Active
Travel
England

Your Ref: 23/01493/REM
Our Ref: ATE/23/00153/RM
Date: 18 April 2024

Active Travel England Planning Response Detailed Response to an Application for Planning Permission

Site Address: PROPOSED HIMLEY VILLAGE NORTH WEST BICESTER,
MIDDLETON STONEY ROAD, BICESTER, OX26 1RT

TITLE  
**S278 OFFSITE HIGHWAY WORKS  
 PRIMARY ACCESS JUNCTION  
 GENERAL ARRANGEMENT  
 SHEET 1**

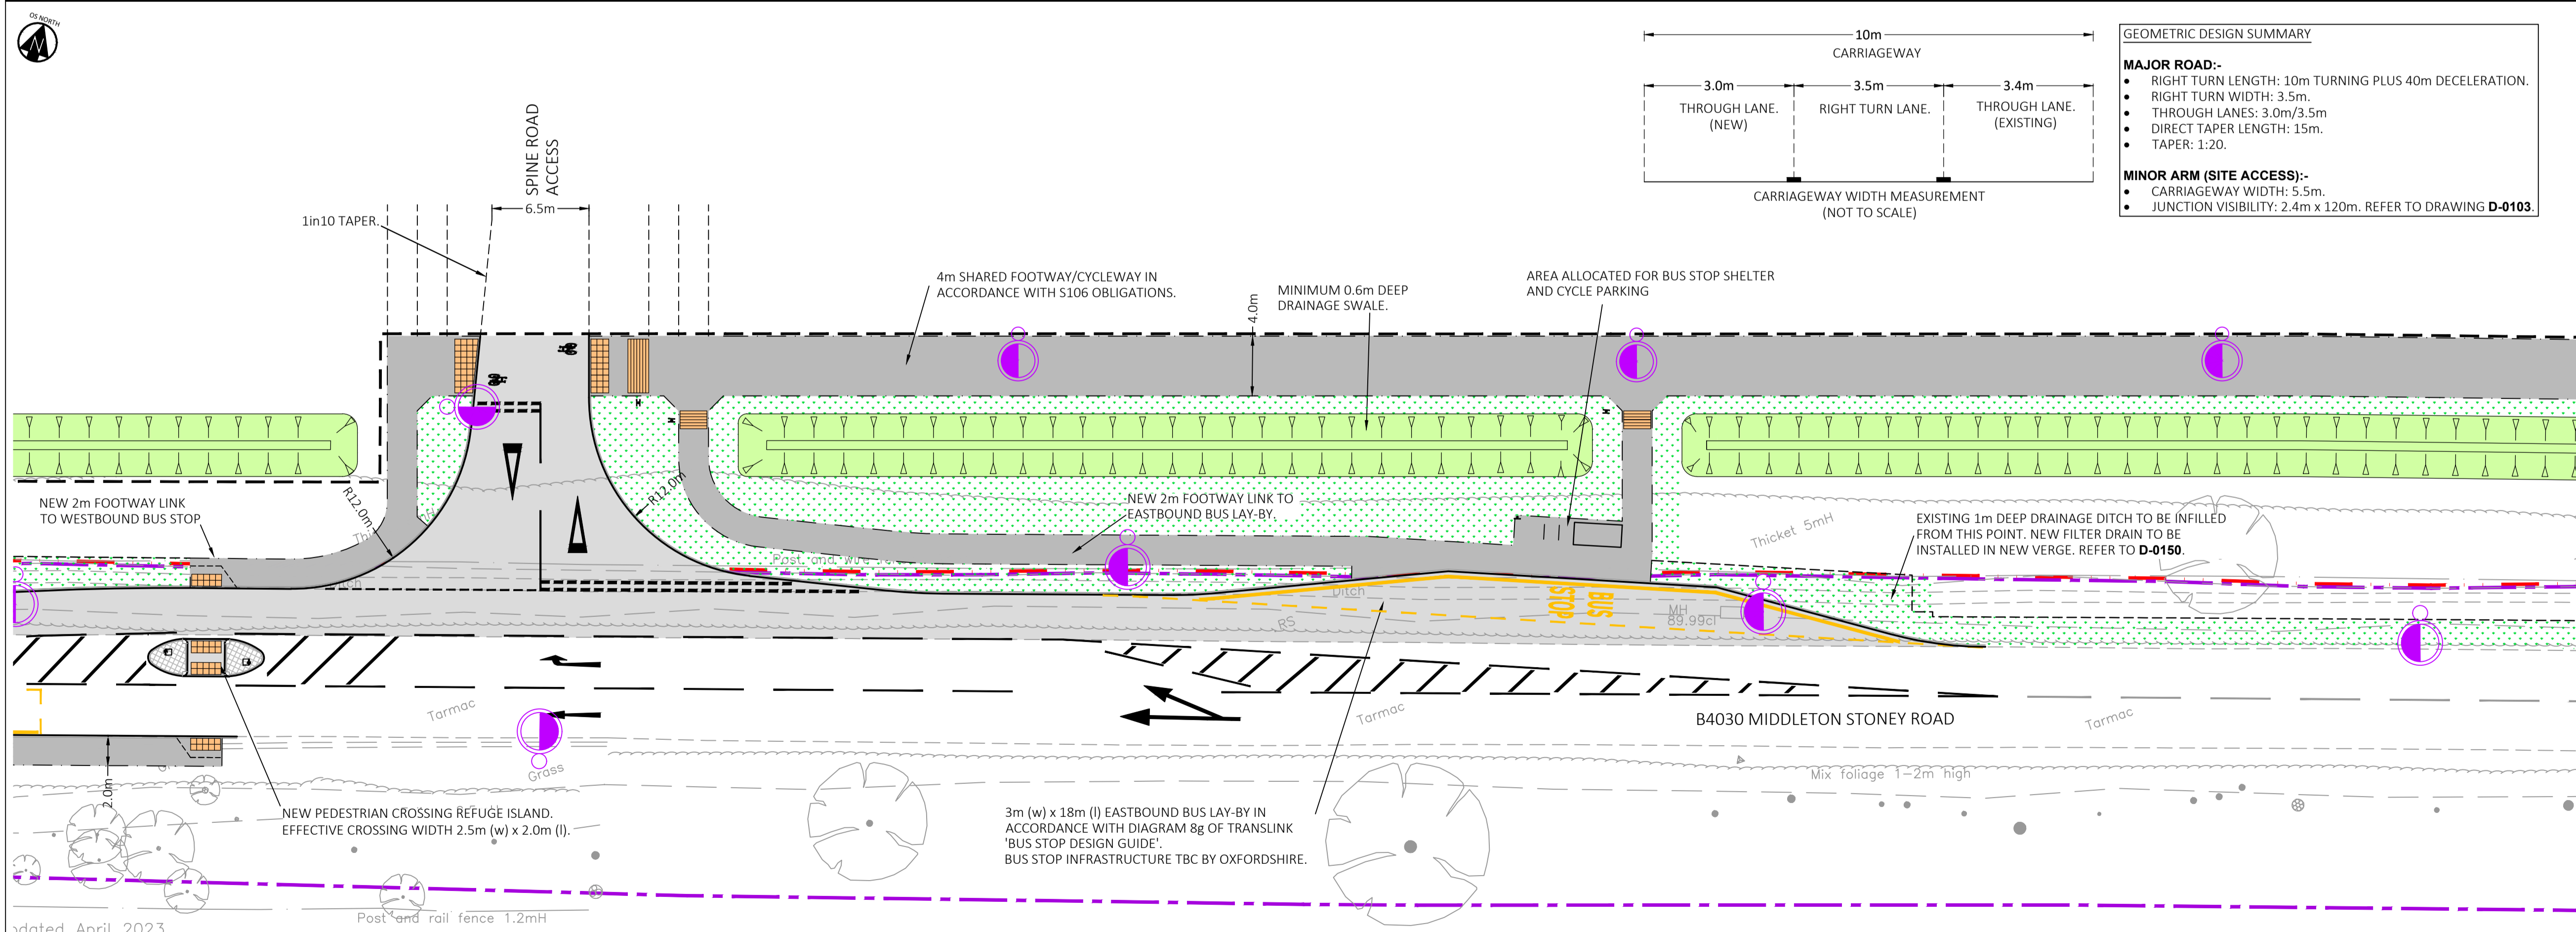
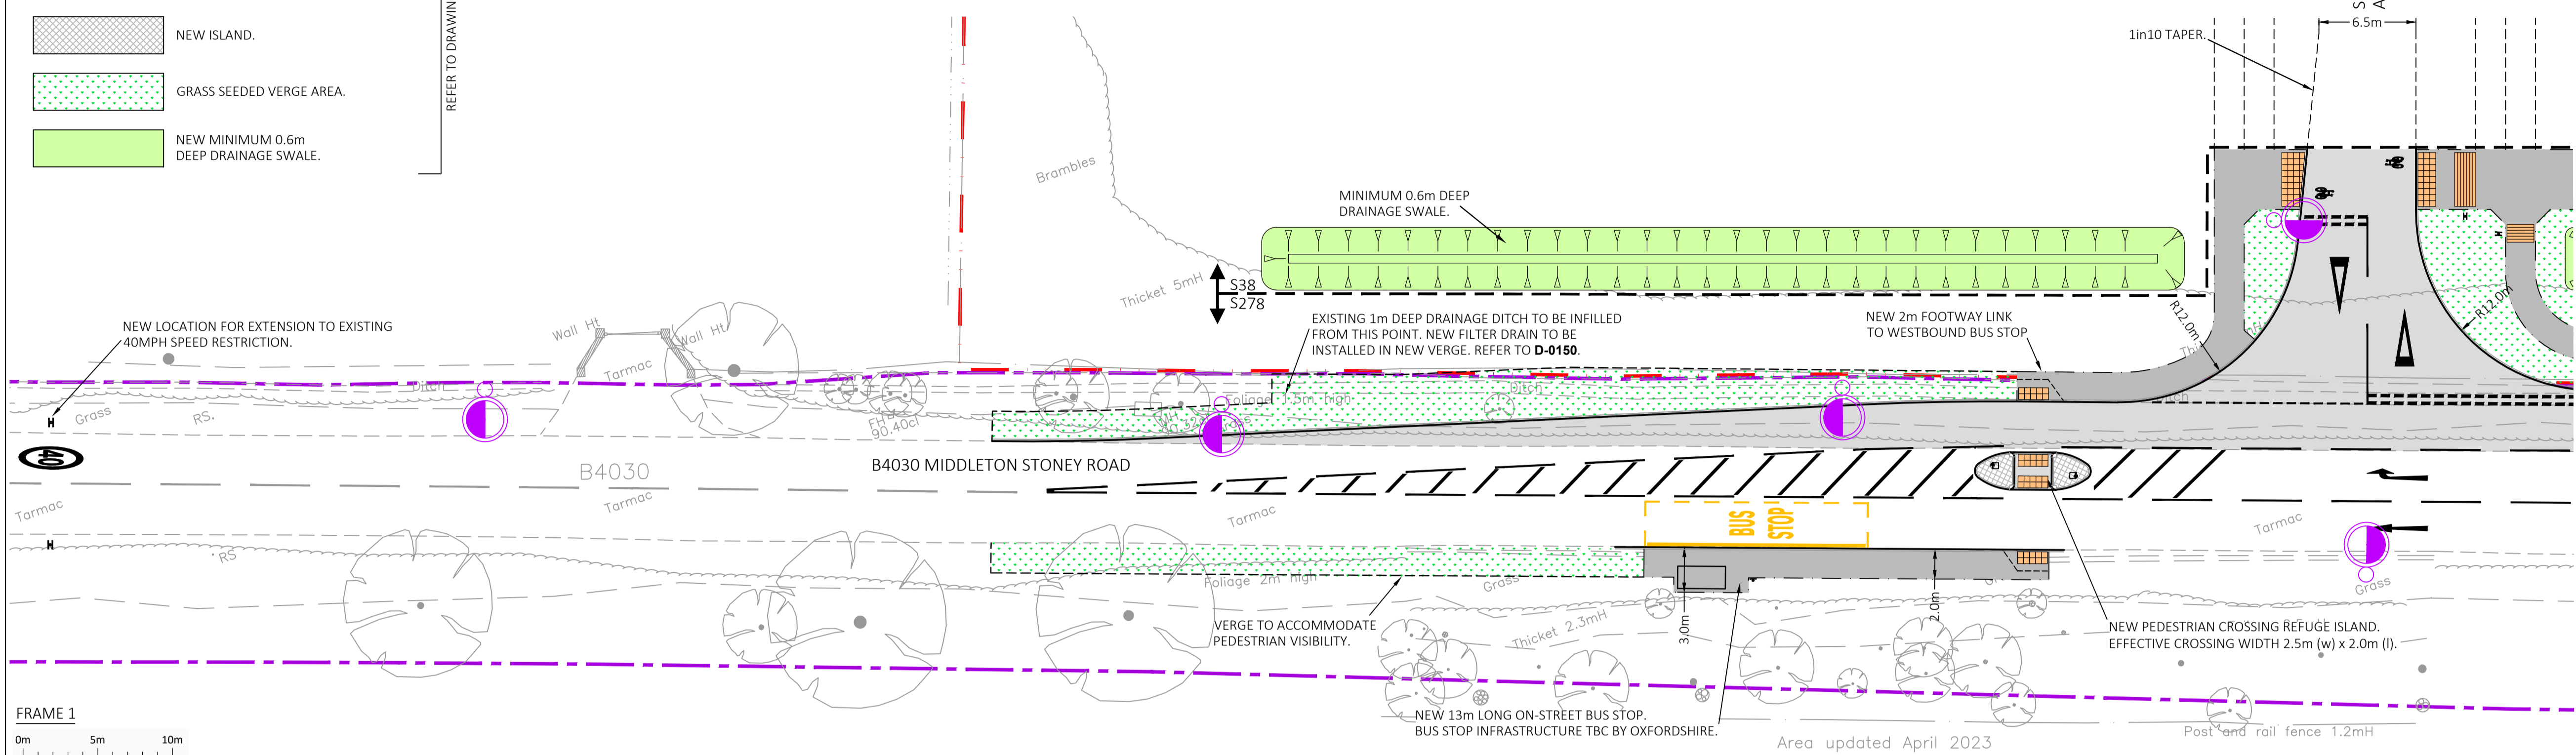
The above improvements are welcome and supported, however it is felt the access to the Primary Spine Road would also benefit from the same priority arrangement proposed at the Secondary Street access. This would assist those joining infrastructure within the proposal site as well as future proofing connections to the west.

TITLE  
**S278 OFFSITE HIGHWAY WORKS  
PEDESTRIAN/CYCLE LINK  
GENERAL ARRANGEMENT  
SHEET 3**

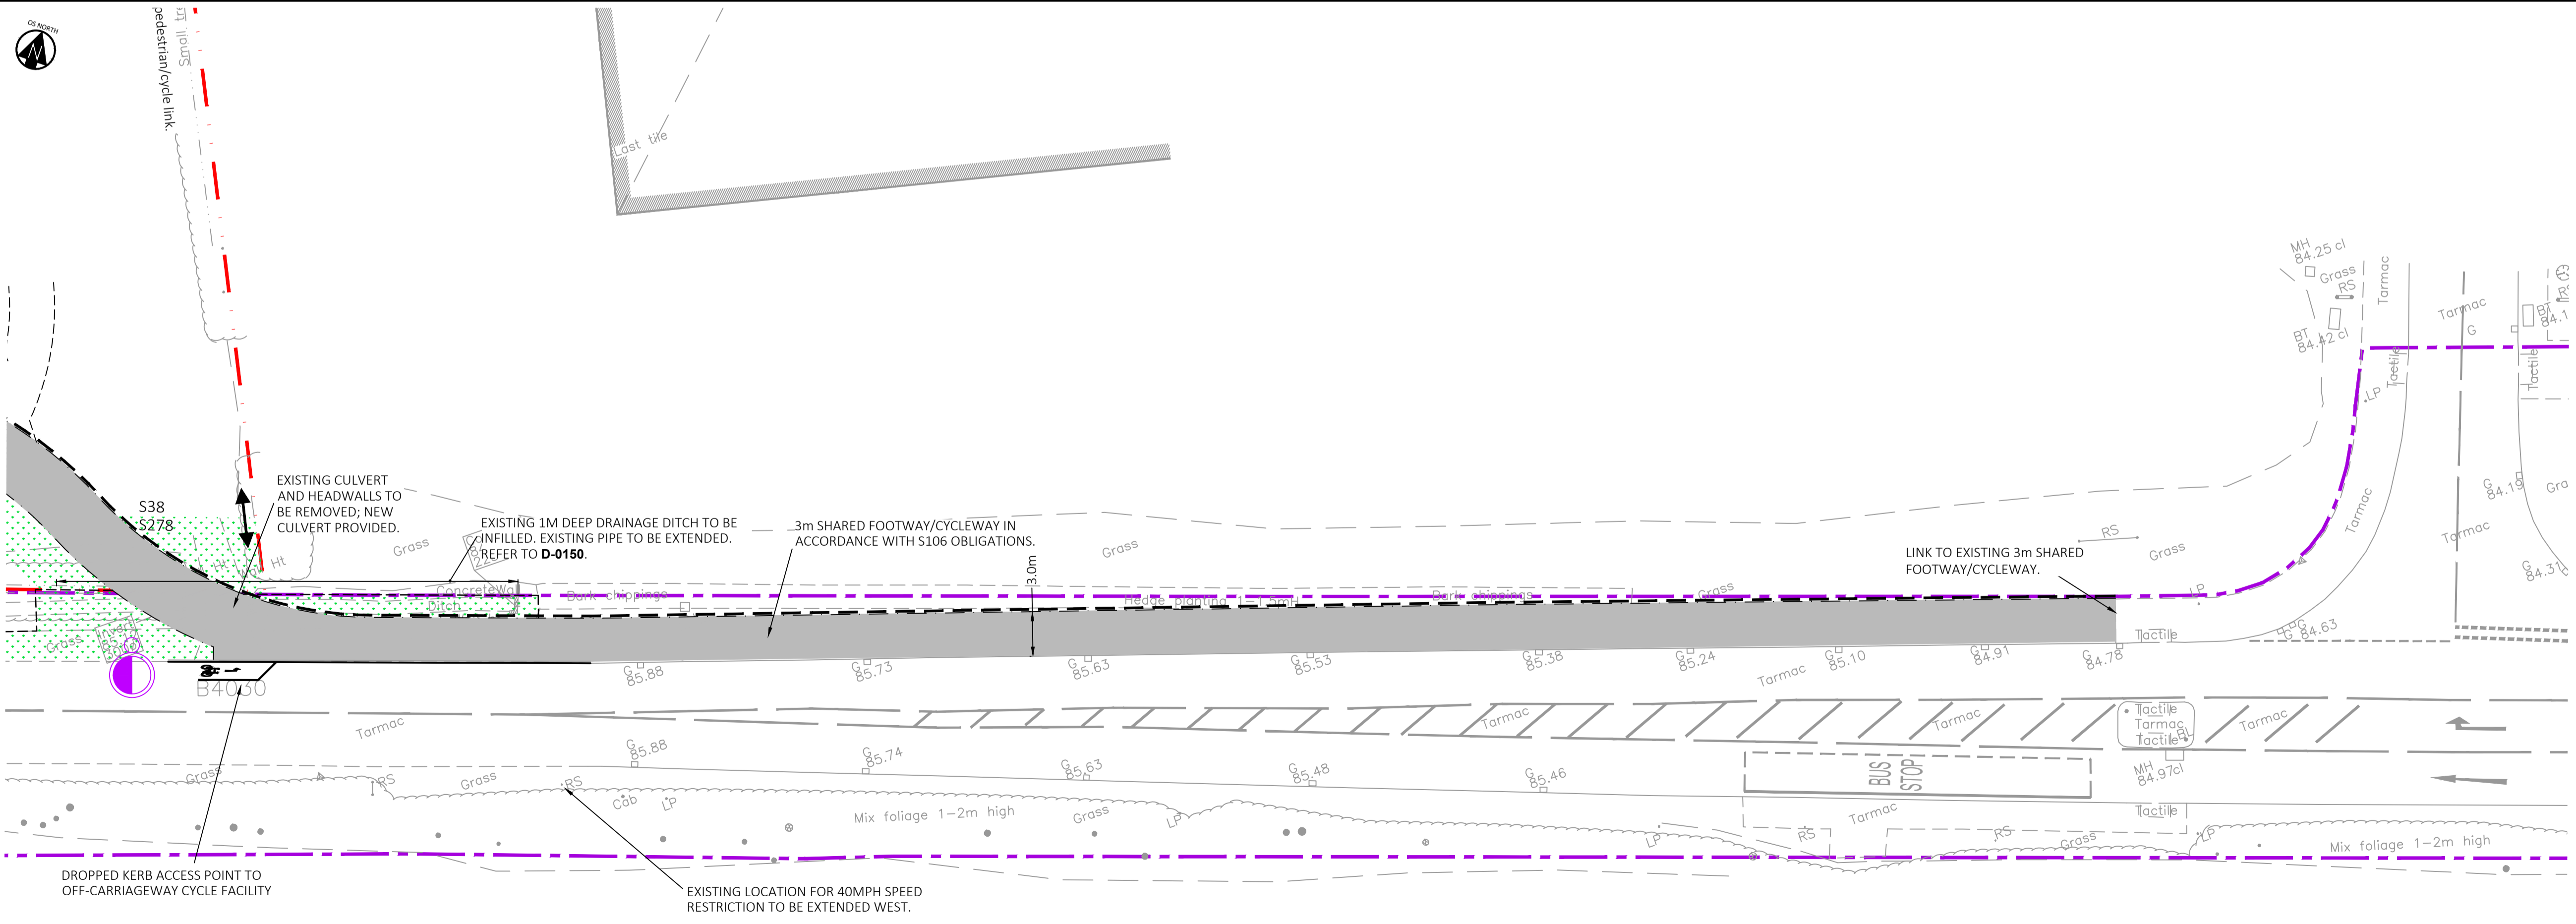
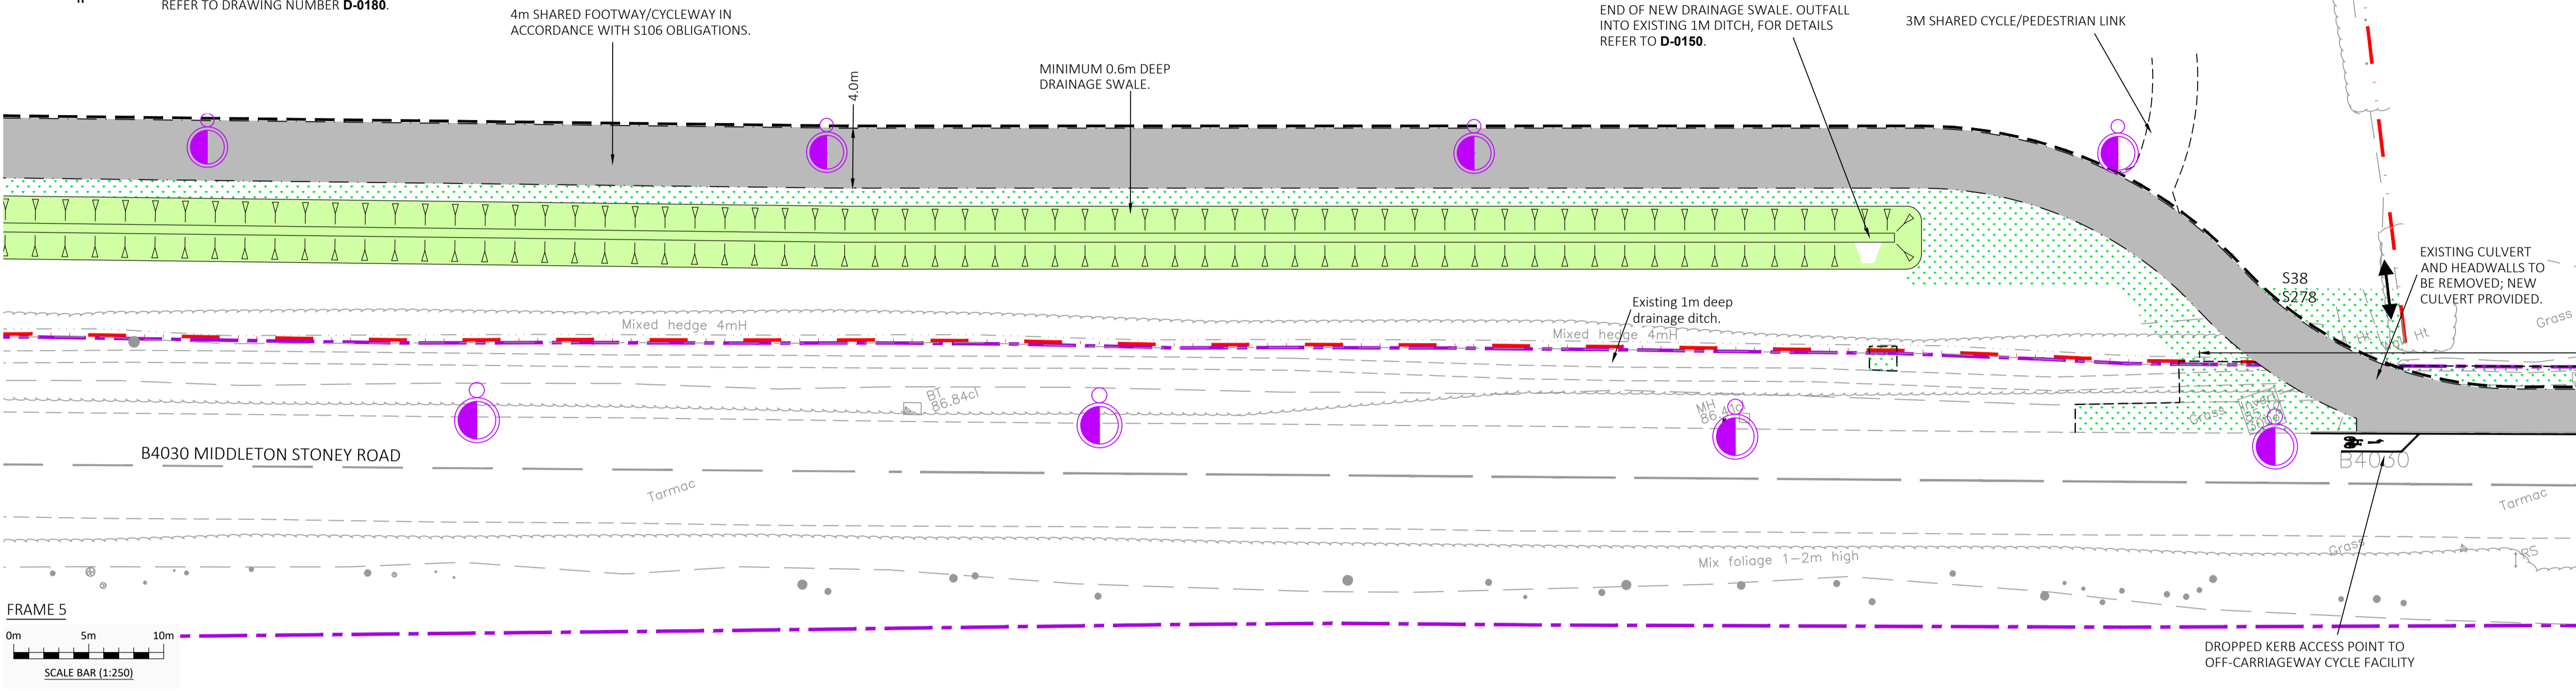
ATE suggested a segregated walking and cycle route along B4030 Middleton Stoney Road would significantly increase the legibility, safety and therefore attractiveness for those considering whether to walk, wheel and cycle, in line with Figure 4.1 of LTN 1/20. It appears as though a shared use facility has been retained; however the following improvements have been made.

- A 'lazy S' bend has been introduced to ensure a smooth transition between the on site 4 metre wide footway / cycleway and the off site 3 metre wide footway / cycleway.
- A continuous footway/cycleway has been provided at the entrance to the Secondary Street from B4030 Middleton Stoney Road with vehicles required to give way.

To the east of the 'lazy S' bend it is still unclear whether a buffer is to be included between the shared use path and highway.
